June 20, 2021

Subject: The Ashville House Plan
Harnett County

I reviewed the construction drawings and the truss and beam designs furnished by Comtech. Comtech also provided the reaction loads.

### Foundation Plan

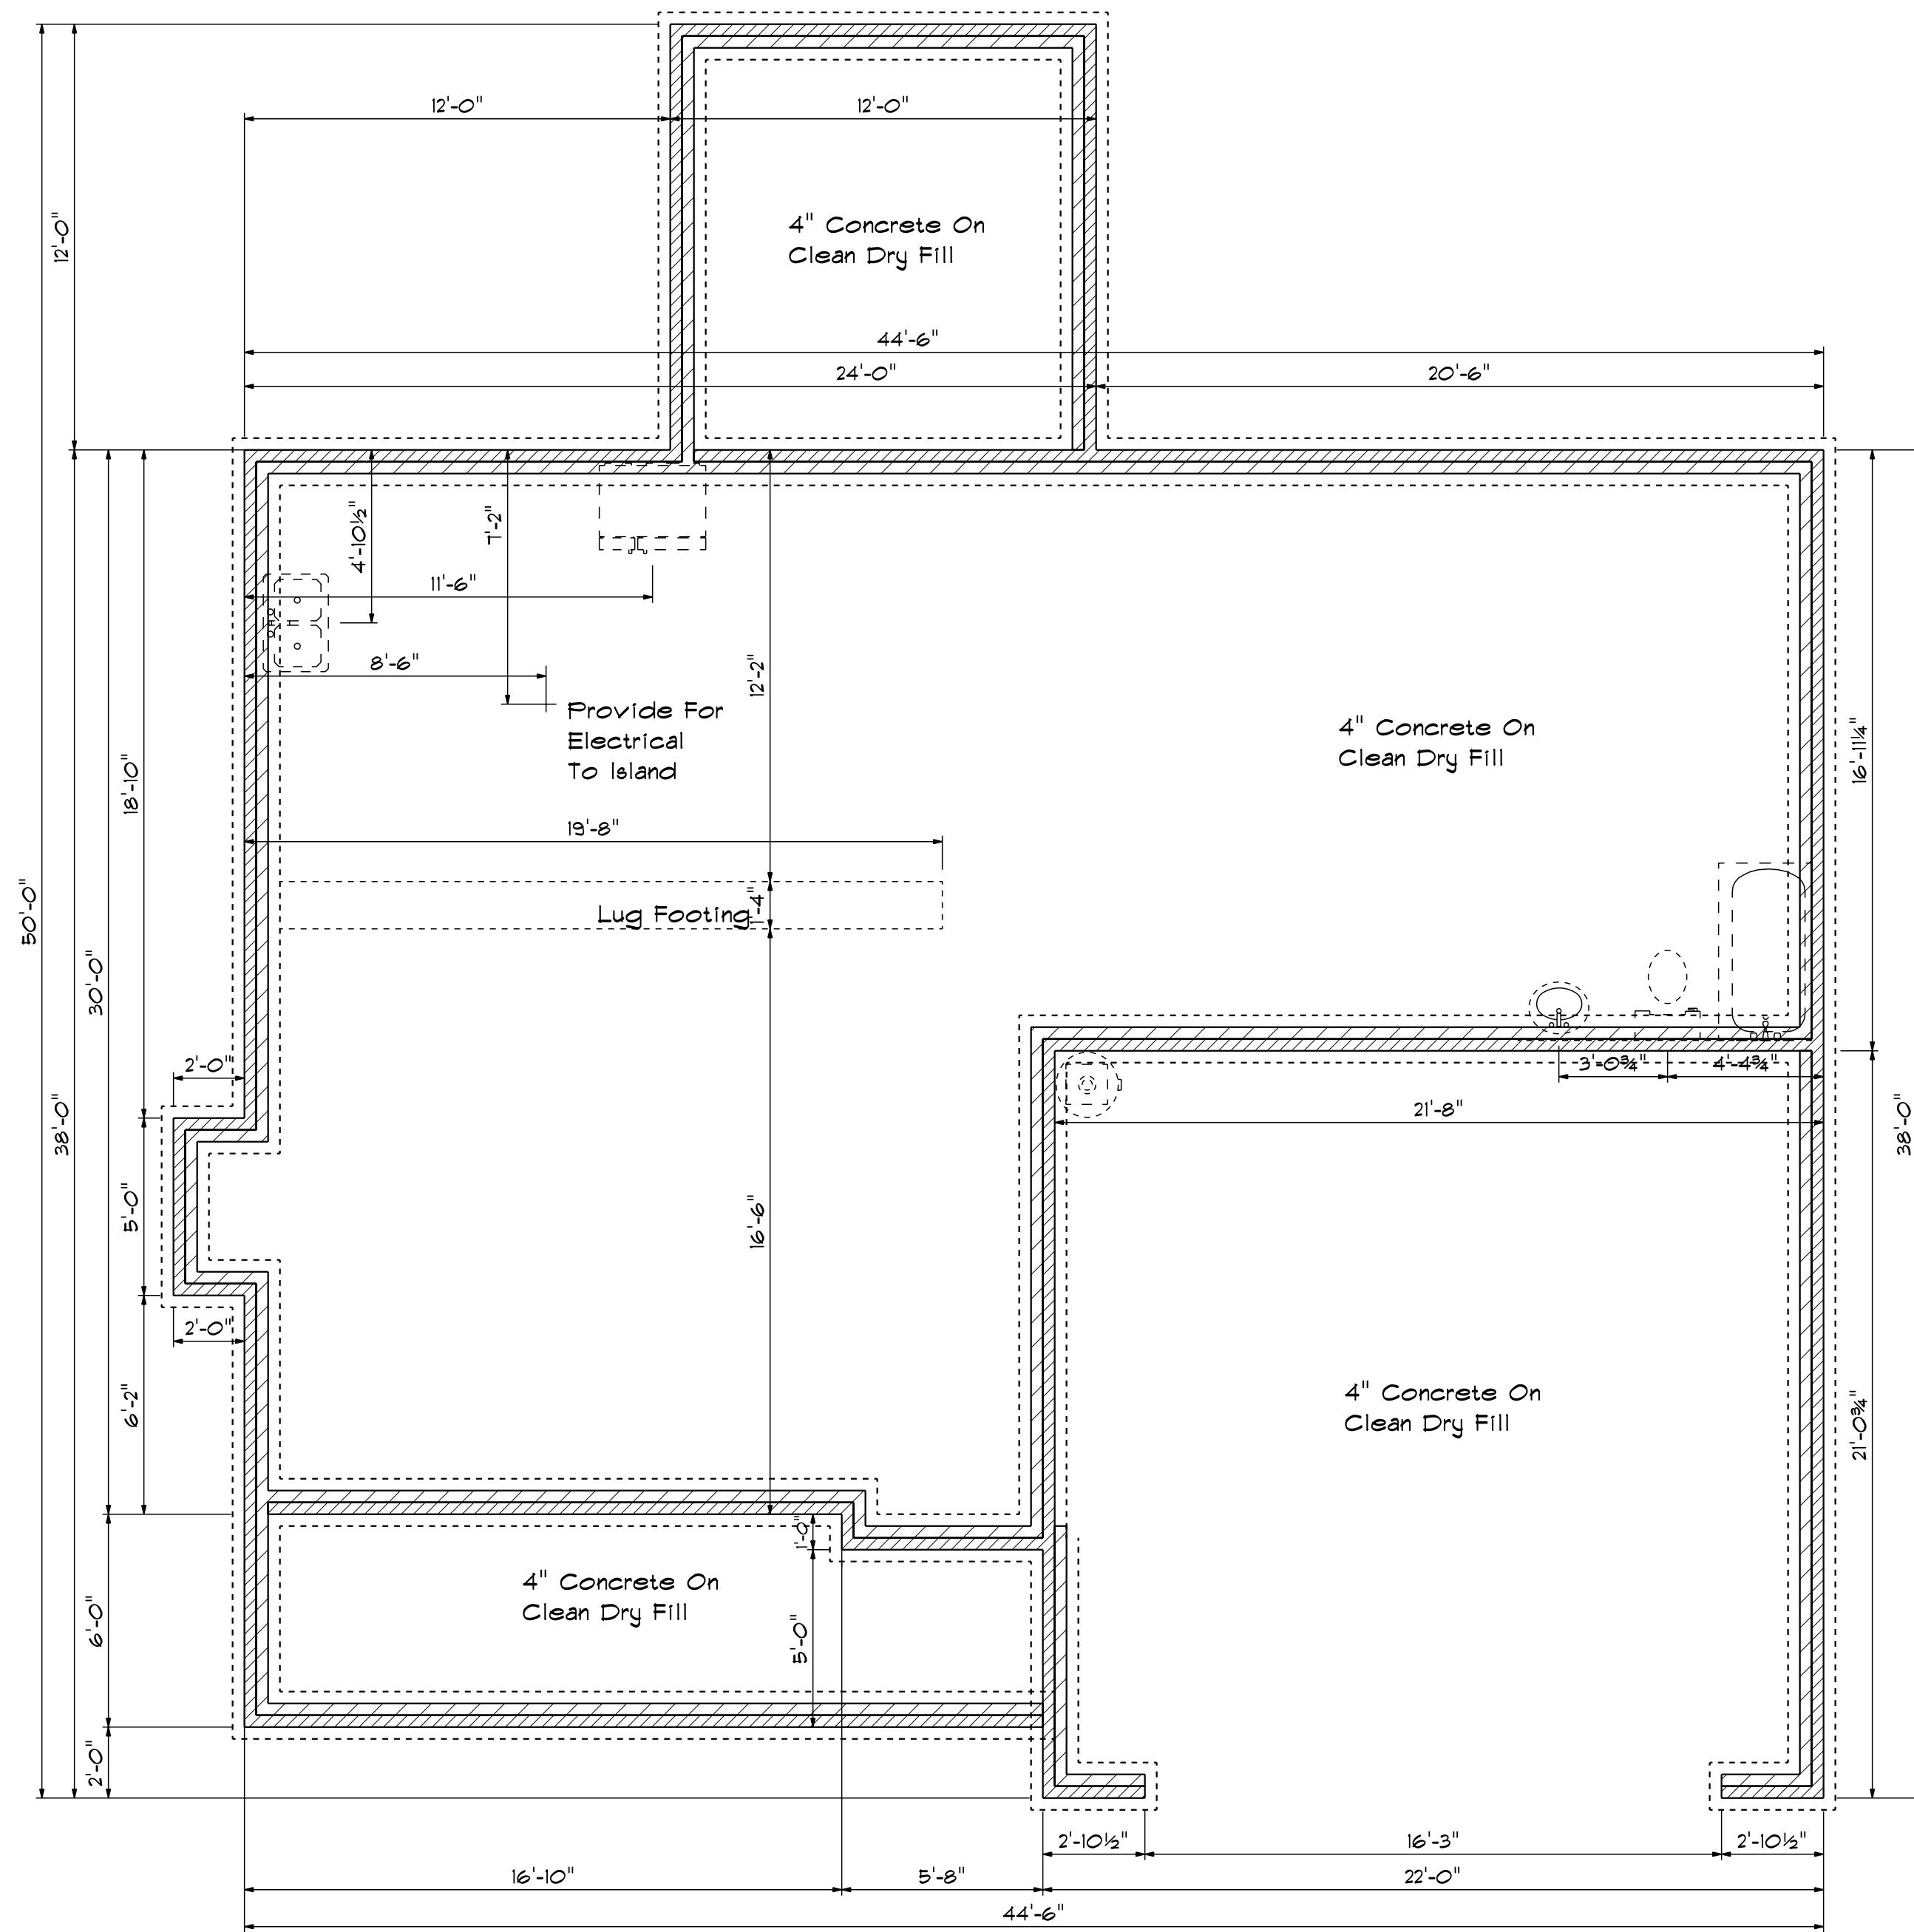
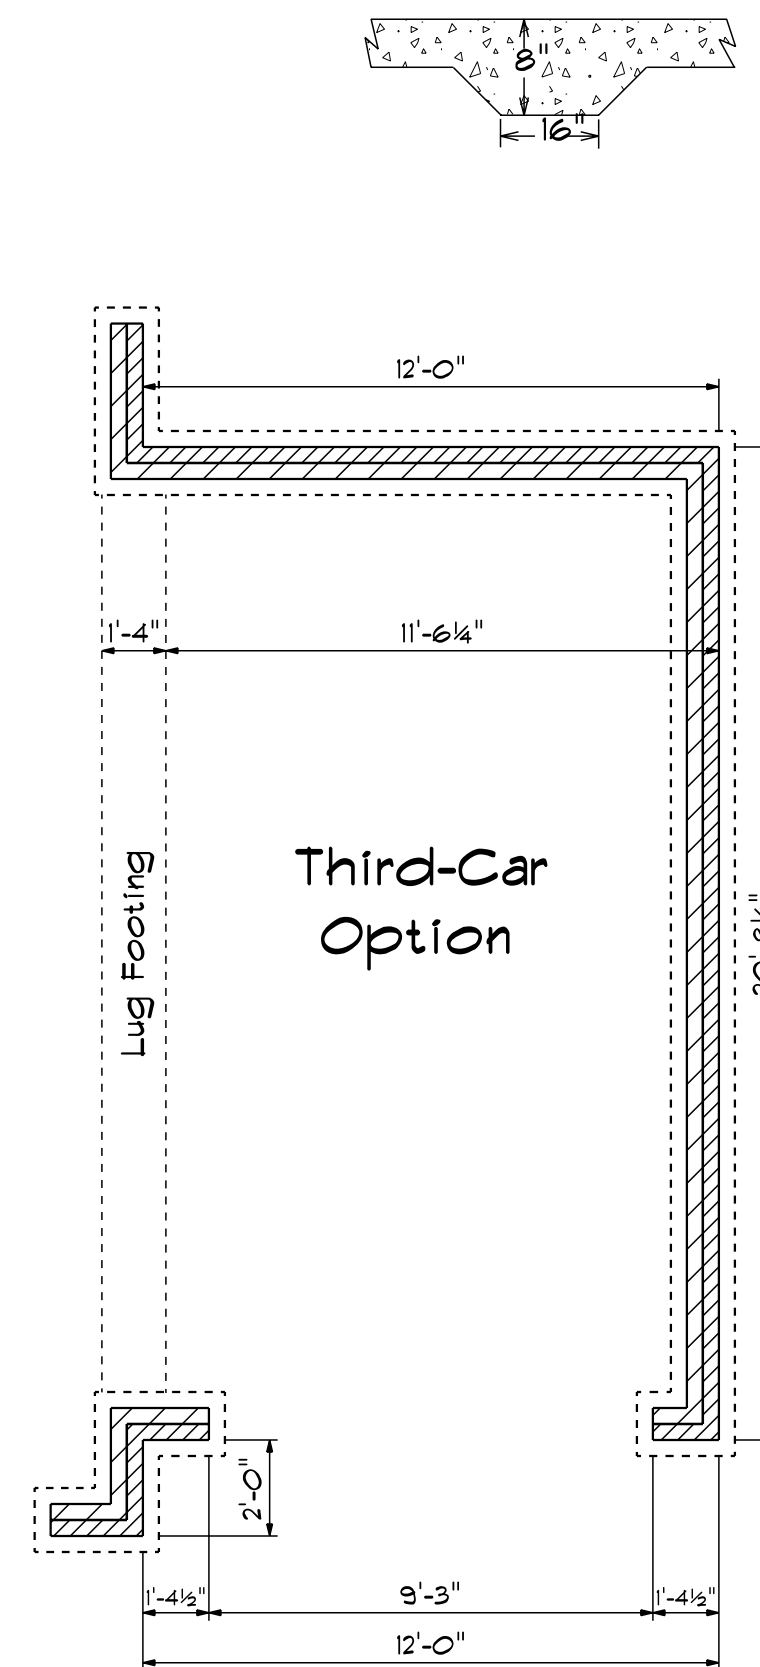
At the junction where trusses C1GR and B1GR meet, there is a significant load being transferred to the footing below. However, the 36" x 36" x 8" footing will support the load.
